Re: Dogger Bank South Project Targeted Non-statutory Consultation – Written representation (deadline 29/1/25)

I am responding to the above consultation as an Interested Party (20050002) and providing some feedback on the proposed changes/ current version of the proposal. I am a local resident of [REDACTED] who is particularly interested in the impacts of the overland cable route on ancient woodland and veteran trees, particularly Burton Bushes/ Beverley Westwood (a unique site and very popular nature amenity area for the public), both as a community area, as a unique habitat and in terms of archaeological interest.

DRAWING TITLE
Statutory Non-Statutory Nature Conservation Sites (Onshore)

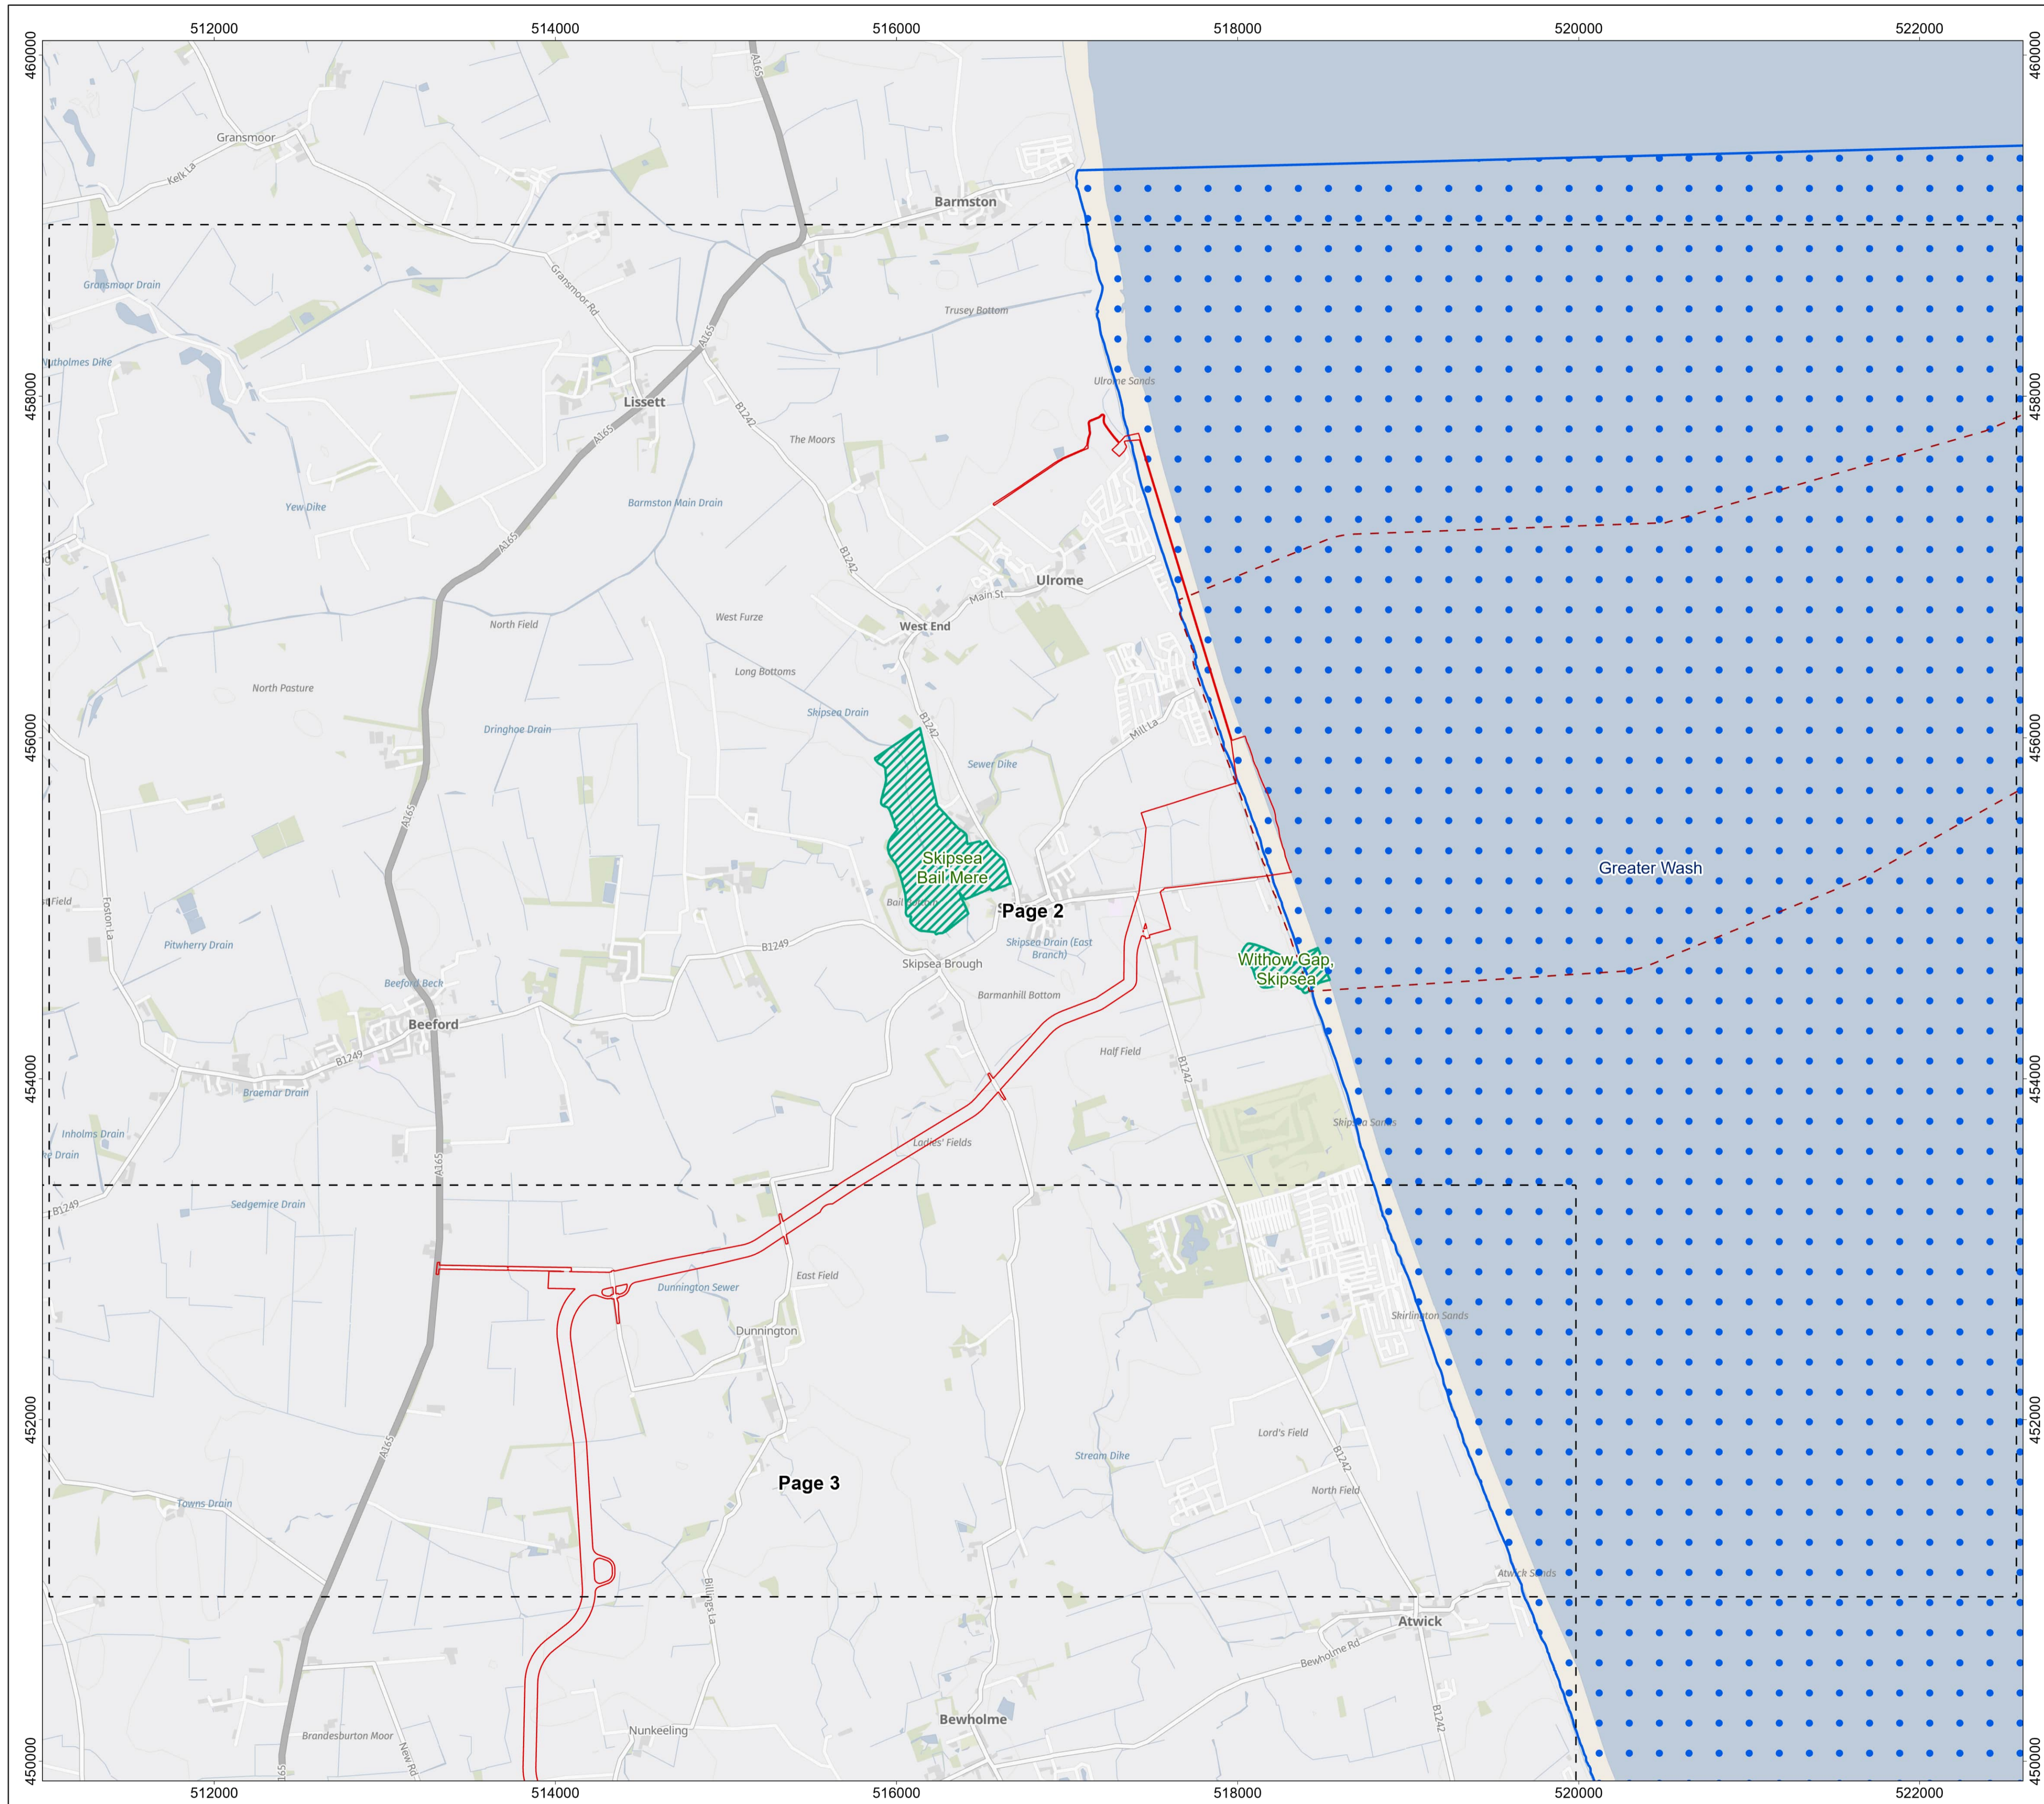
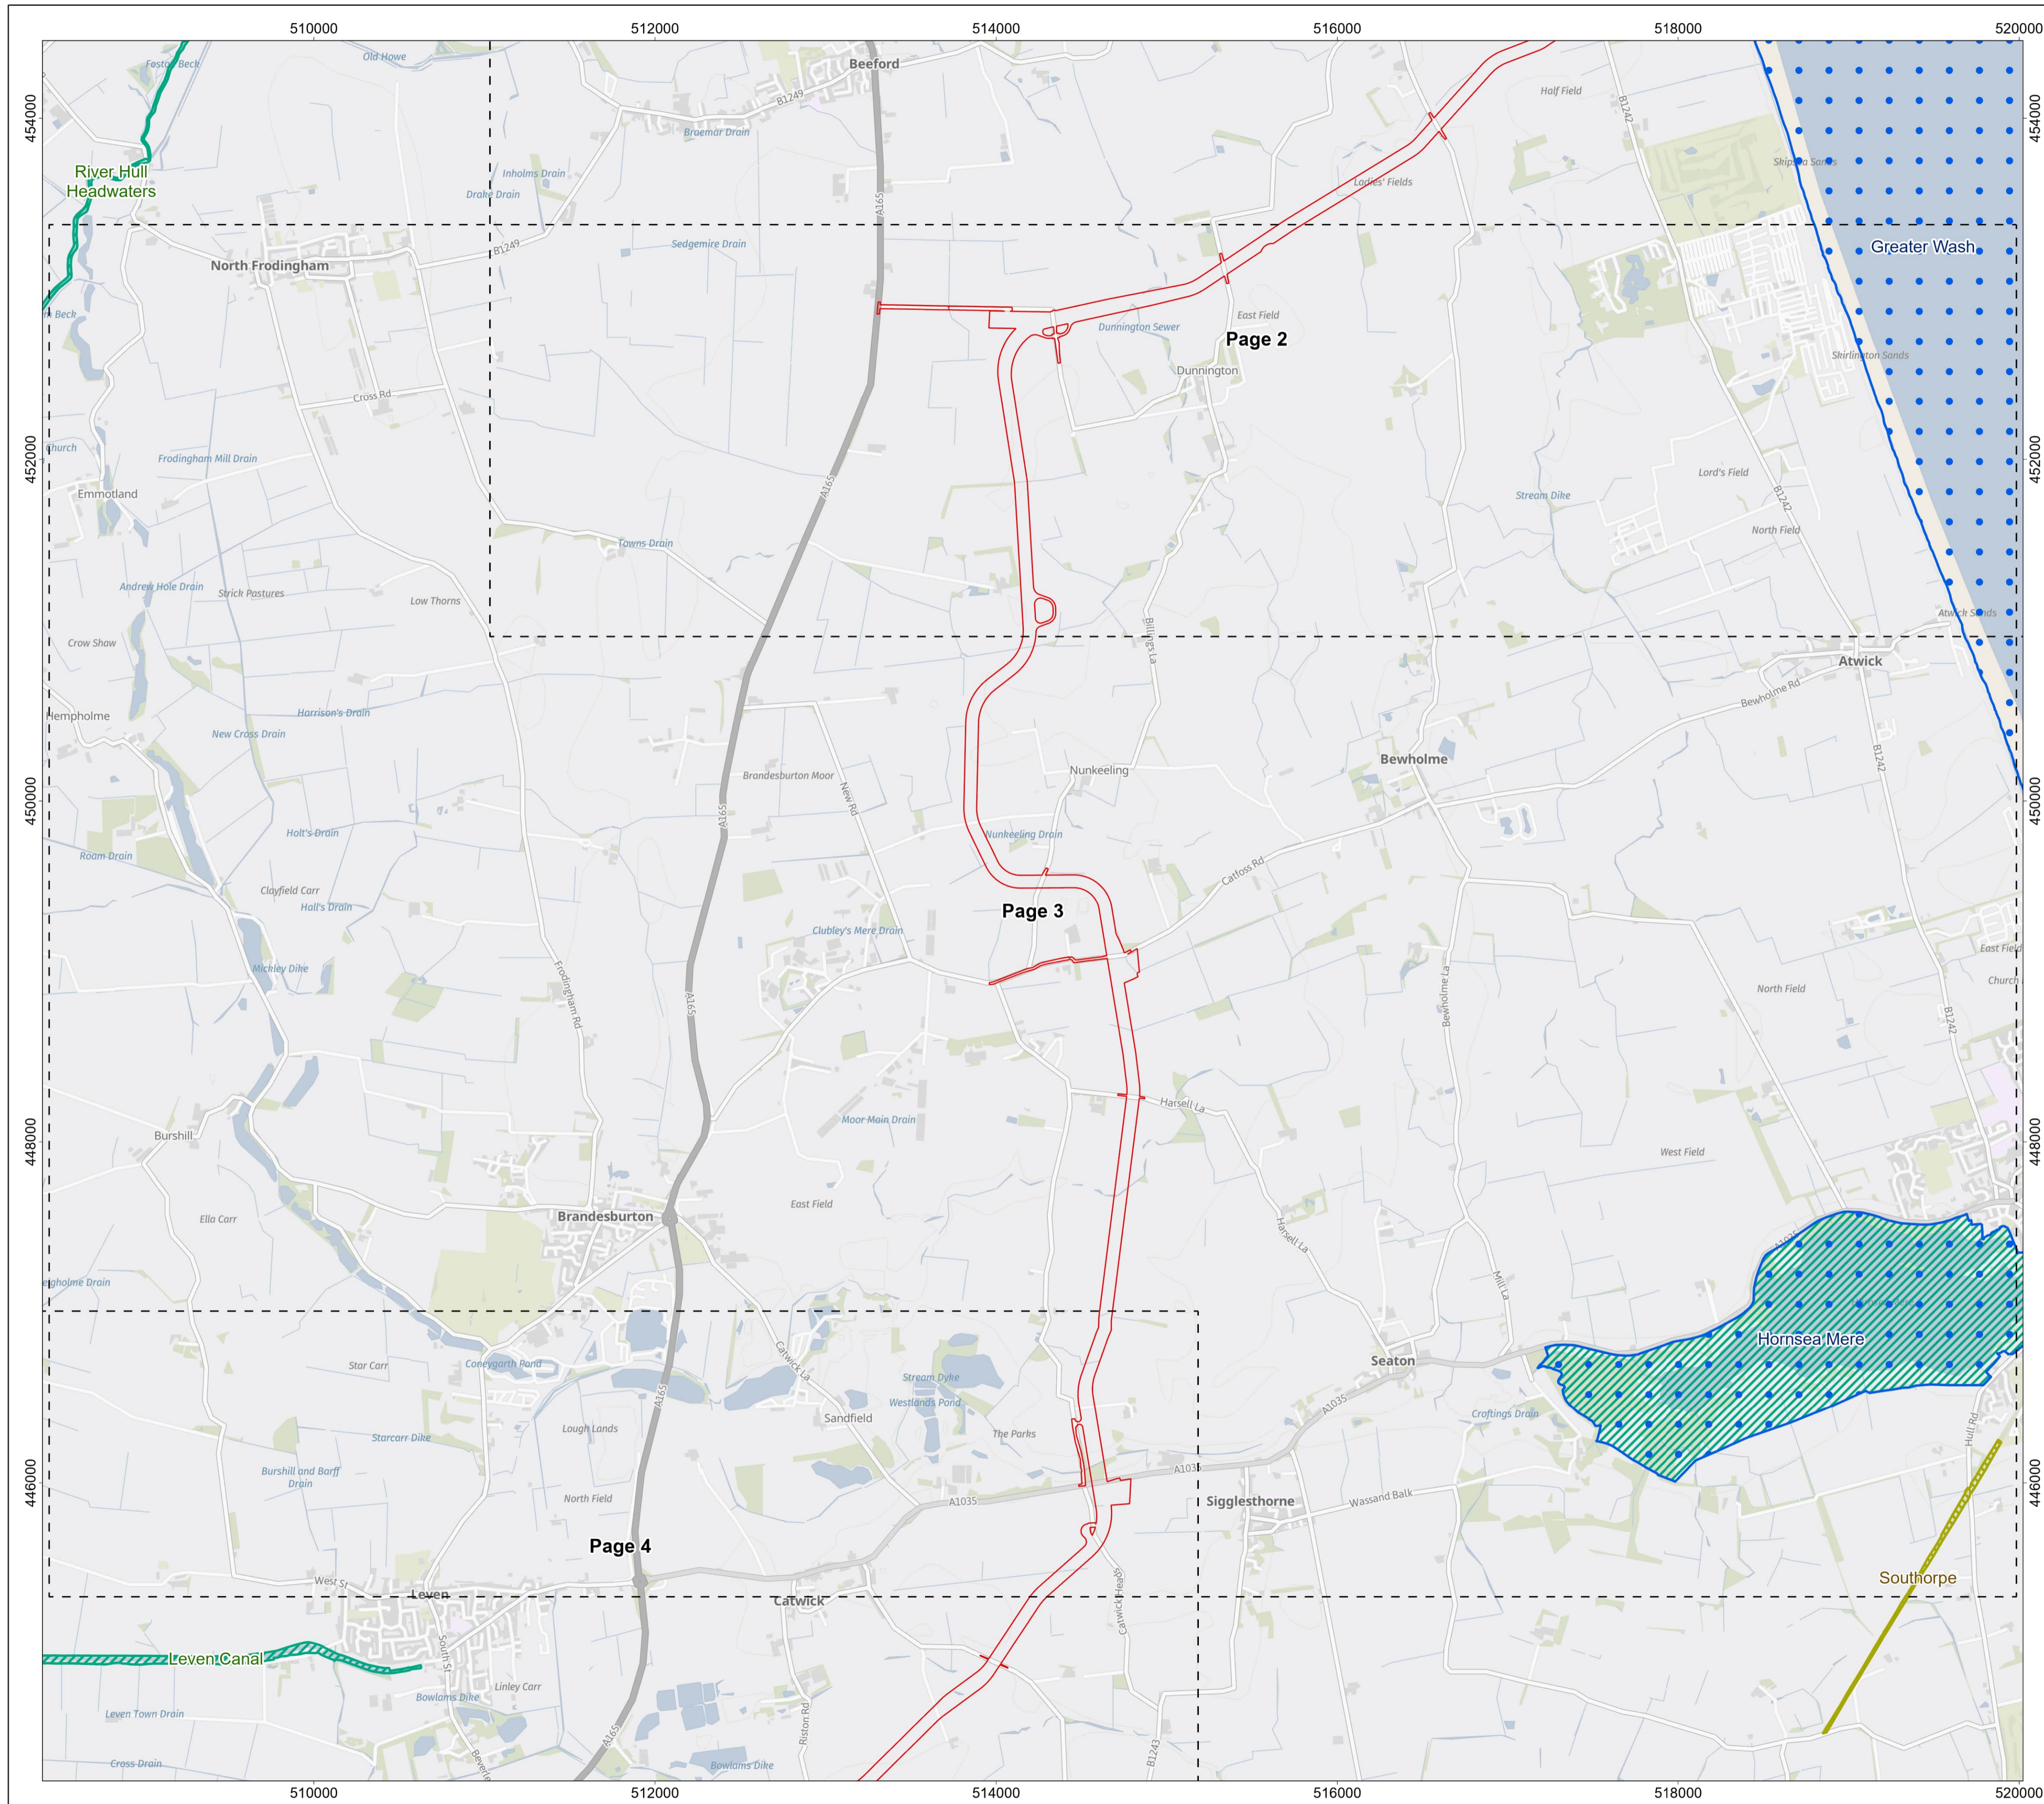
Comment: Can RWE confirm there is no drilling under Burton Bushes or the Westwood? This does not seem to be on the map and should not be allowed.

Whilst the adjustments described in the first two points are welcome, I still contend that the corridor and construction sites and buildings are too close to wildlife habitats/ archaeological SSIs to me (e.g. Burton Bushes) and general peaceful amenity areas on

the Westwood. There appears to be quite a lot of construction of 'temporary construction compounds' near to or next to various parts of the Westwood. The York road will be significantly disrupted.
